From: Laura Gibbons [REDACTED]
Sent: 04 May 2021 15:28
To: Anita Gardner <Anita.Gardner@arun.gov.uk>
Cc: Planning.Responses <Planning.Responses@arun.gov.uk>
Subject: Re: FW: FW: Planning Consultation on: CM/11/21/DOC

Application No: CM/11/21/DOC

Site Address: Scyld Horsemere Green Lane Climping BN17 5QZ

Description of Works: Approval of details reserved by condition imposed under CM/21/19/PL relating to conditions 11-surface water drainage scheme, 12-discharge of flows to water courses or for the culverting, diversion, infilling or obstruction of any water course on or adjacent to site & 13-maintenance and management of surface water drainage system.

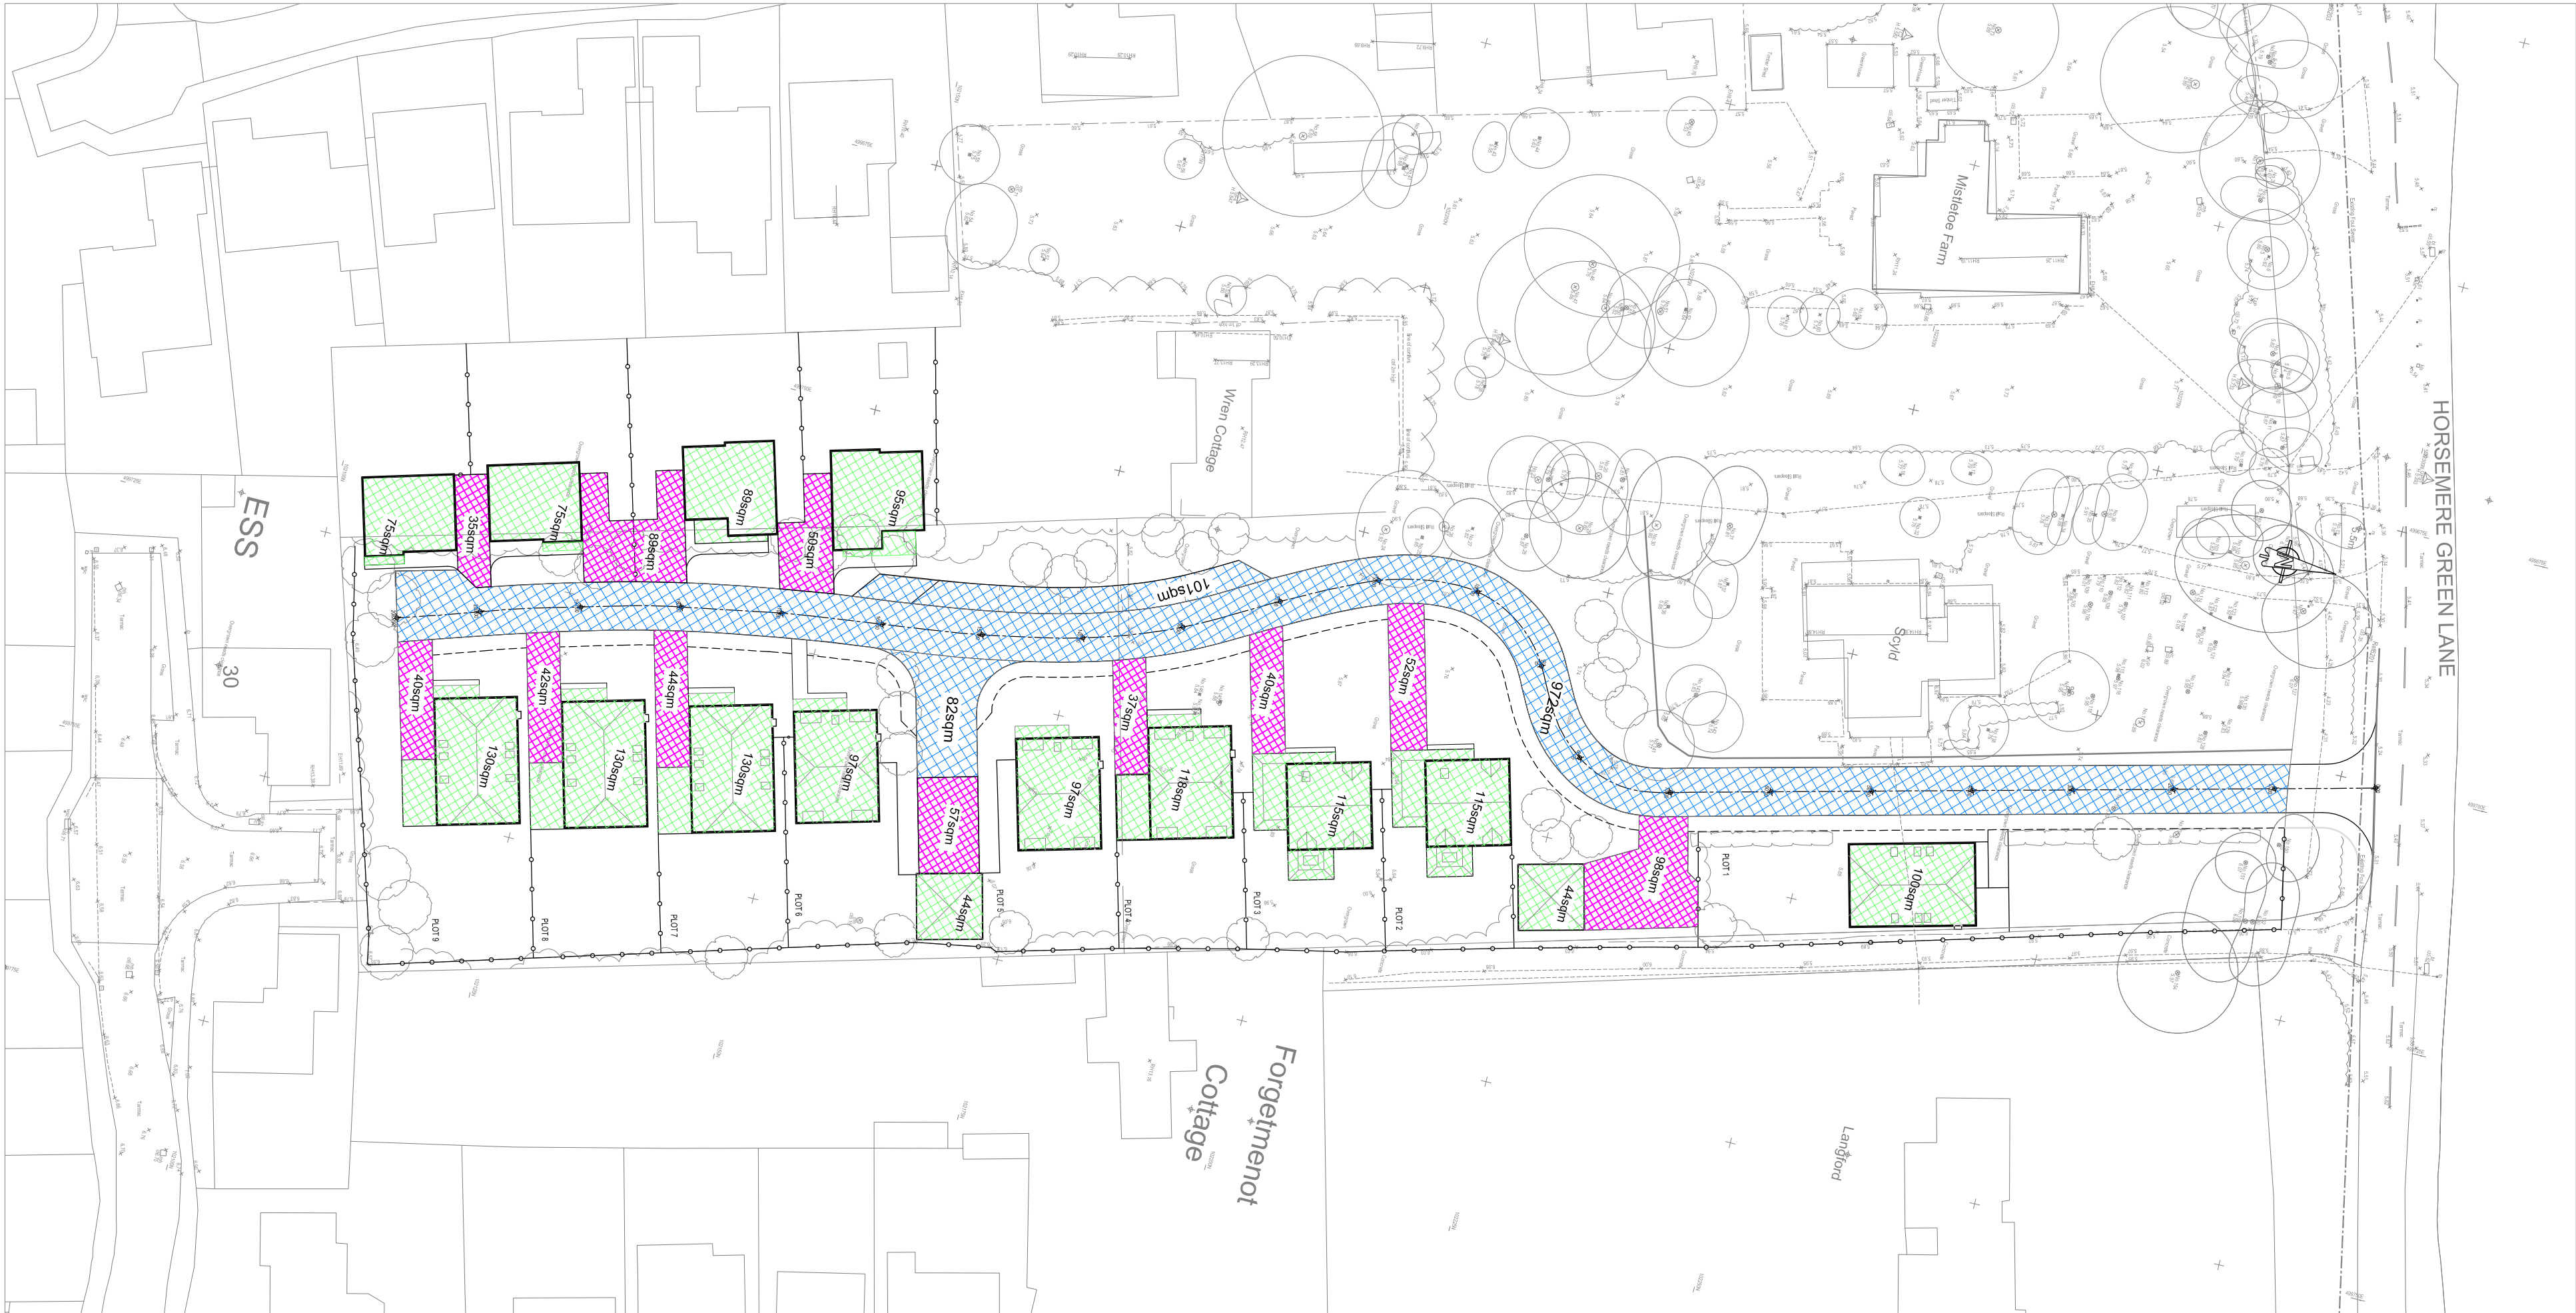
2. The impermeable areas plan appears to use an old layout, not the latest layout as approved under CM/55/20/PL. Please provide an updated impermeable areas plan. Updated plan attached to be read alongside the new calculations / drainage modelling. *Okay, point closed.*

2. The impermeable areas plan appears to use an old layout, not the latest layout as approved under CM/55/20/PL. Please provide an updated impermeable areas plan. Updated plan attached to be read alongside the new calculations / drainage modelling. *Okay, point closed.*

DETAIL 1: TYPICAL SECTION SHOWING NEW ENTRANCE AND EXISTING HIGHWAY WITH NEW CULVERT

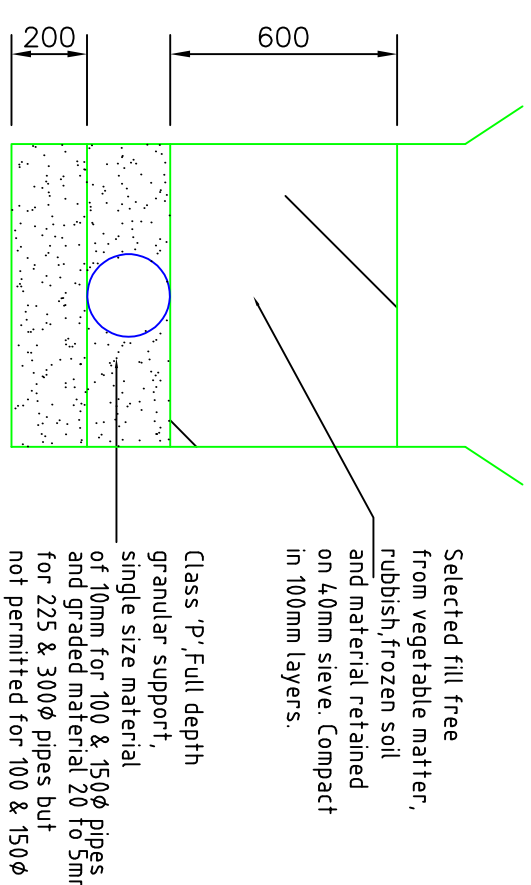
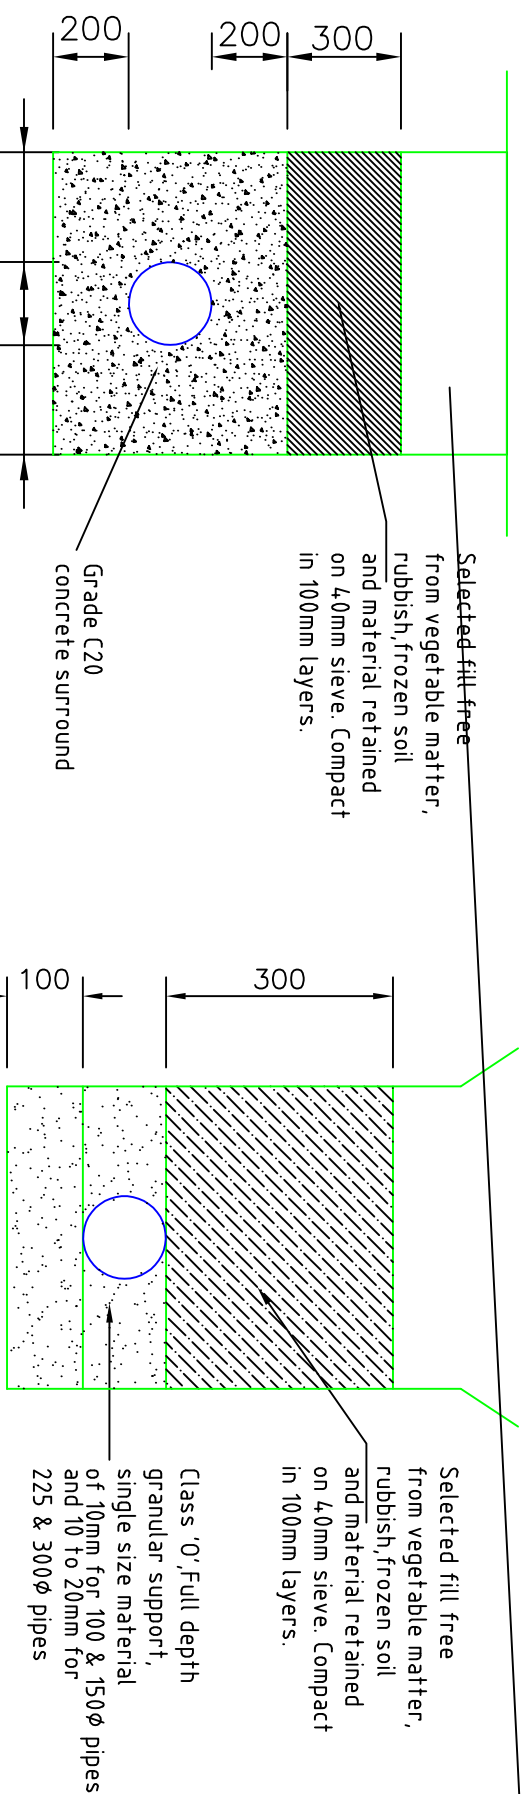
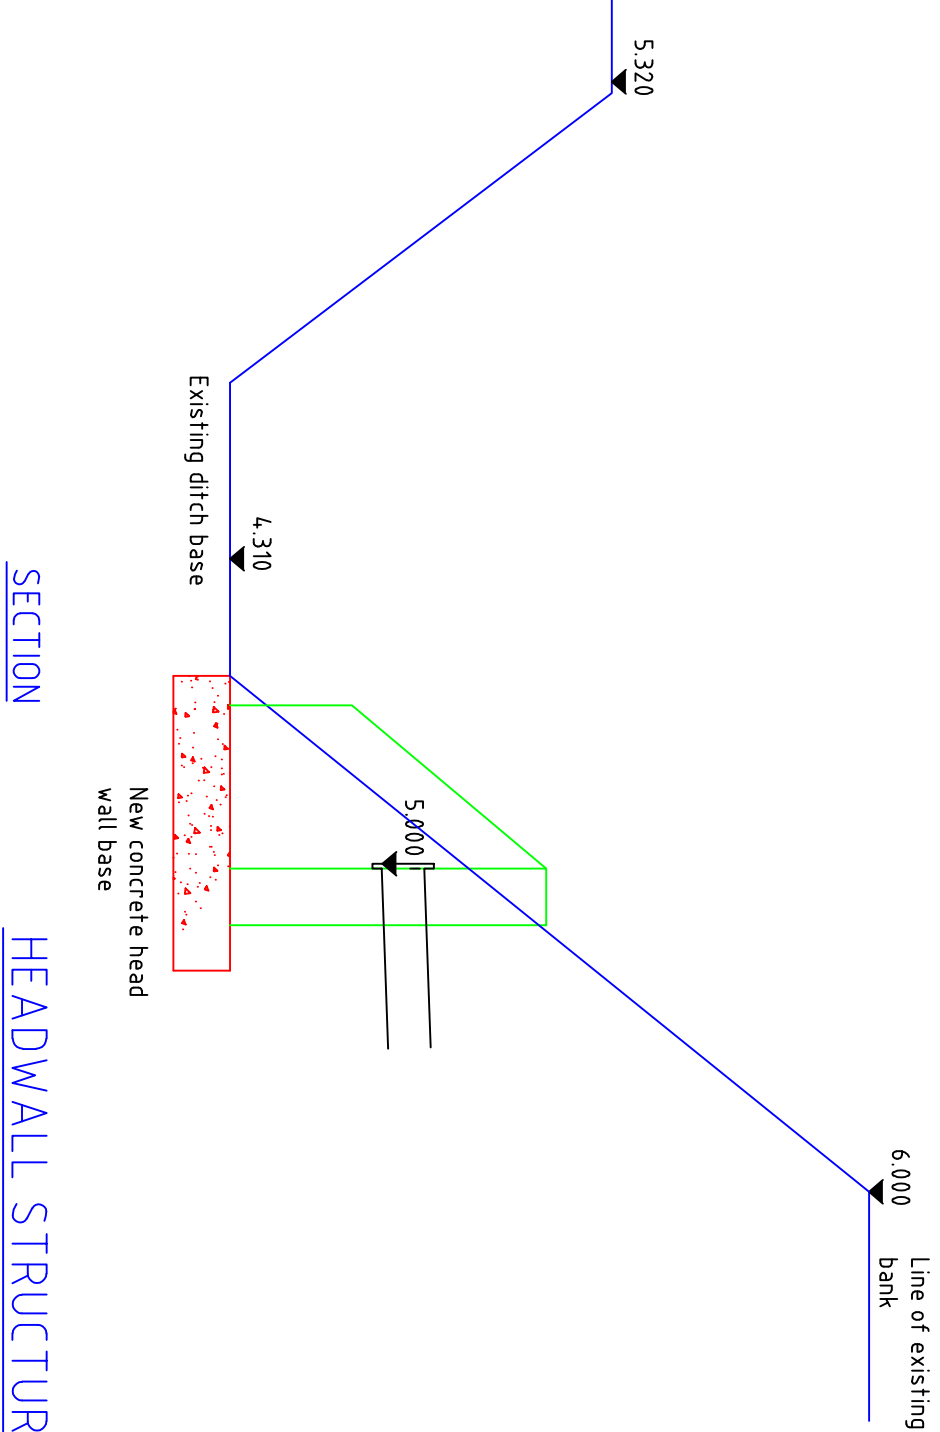
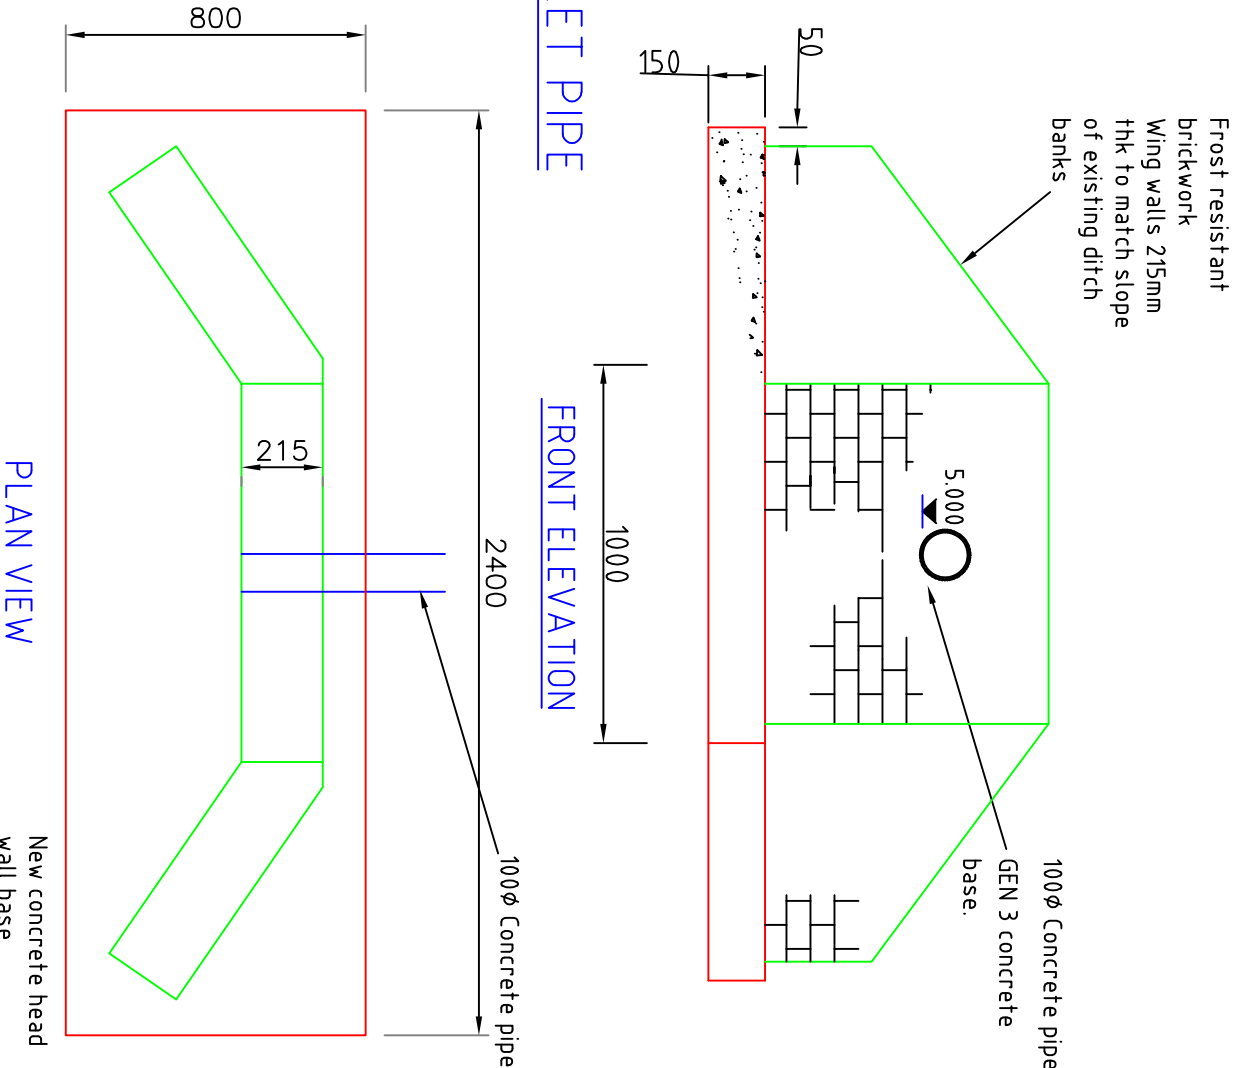
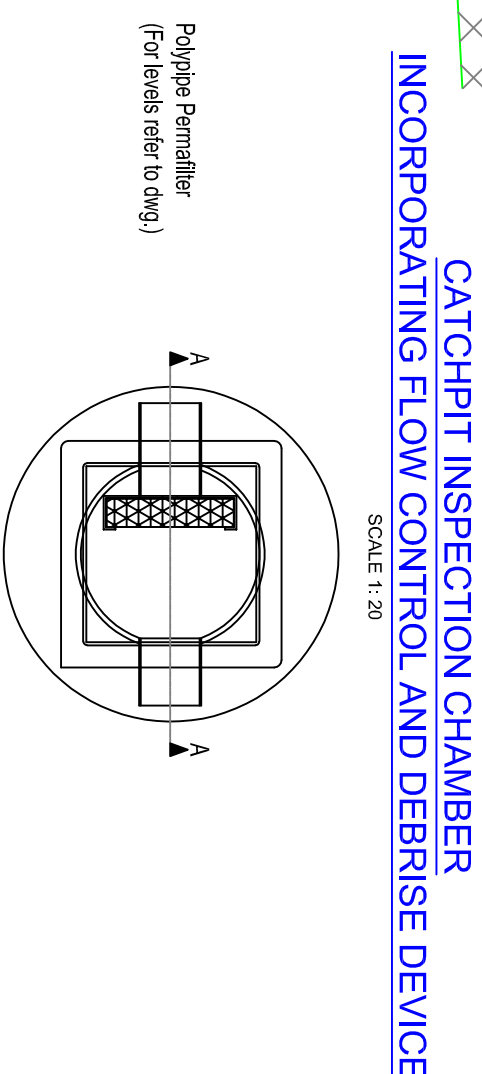
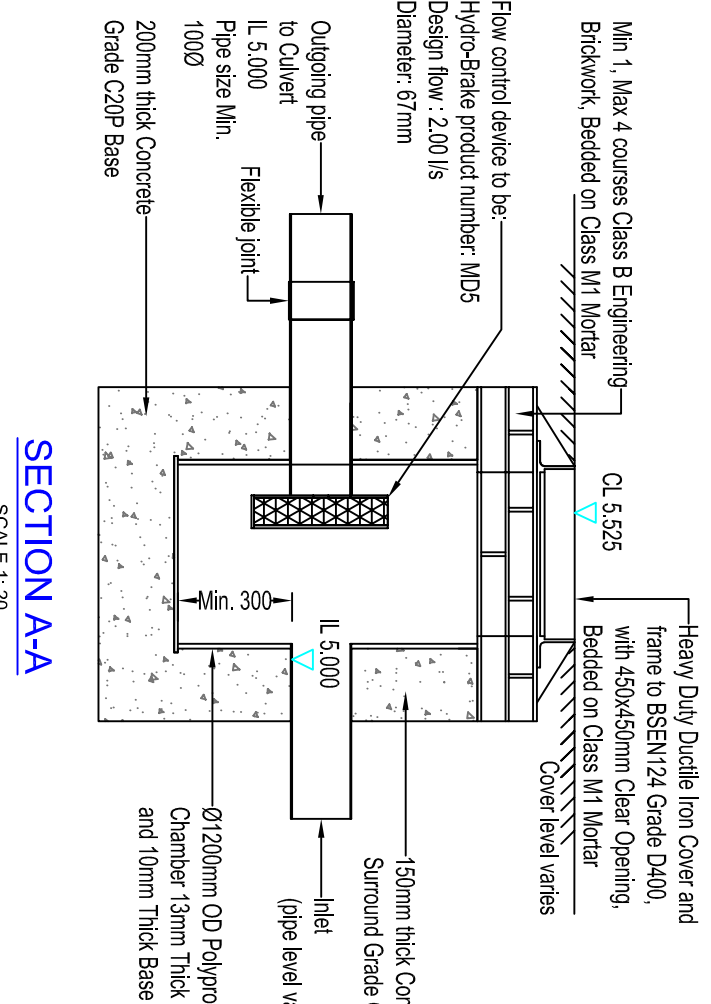
3. The long section on the drainage details sheet 1 refers to a hydrobrake with a restriction of 2.0l/s, which conflicts with the calculations, other details and layout (although addressing point 1 will affect these). This is now correct after the revised calculations, other details have been updated accordingly. See comment below.

8. I note that it is proposed to have a 100mm thick concrete cover slab over the top of the perforated main pipe, with 150mm each side of pipe work. This would have to be constructed very carefully so as not to cause concrete ingress into the perforated pipe, and it will also result in a strip of road being impermeable. Has the use of diffuser units been considered instead with a small fall in formation over the site? The outlet diffuser unit would have to be at the base of the sub-base. As should the pipe at the downstream end if this is to remain. We have updated the details to show diffuser units where possible. *Okay, please detail invert levels of diffuser units.*

3. The long section on the drainage details sheet 1 refers to a hydrobrake with a restriction of 2.0l/s, which conflicts with the calculations, other details and layout (although addressing point 1 will affect these). This is now correct after the revised calculations, other details have been updated accordingly. See comment below.

8. I note that it is proposed to have a 100mm thick concrete cover slab over the top of the perforated main pipe, with 150mm each side of pipe work. This would have to be constructed very carefully so as not to cause concrete ingress into the perforated pipe, and it will also result in a strip of road being impermeable. Has the use of diffuser units been considered instead with a small fall in formation over the site? The outlet diffuser unit would have to be at the base of the sub-base. As should the pipe at the downstream end if this is to remain. We have updated the details to show diffuser units where possible. *Okay, please detail invert levels of diffuser units. Added onto drawings*
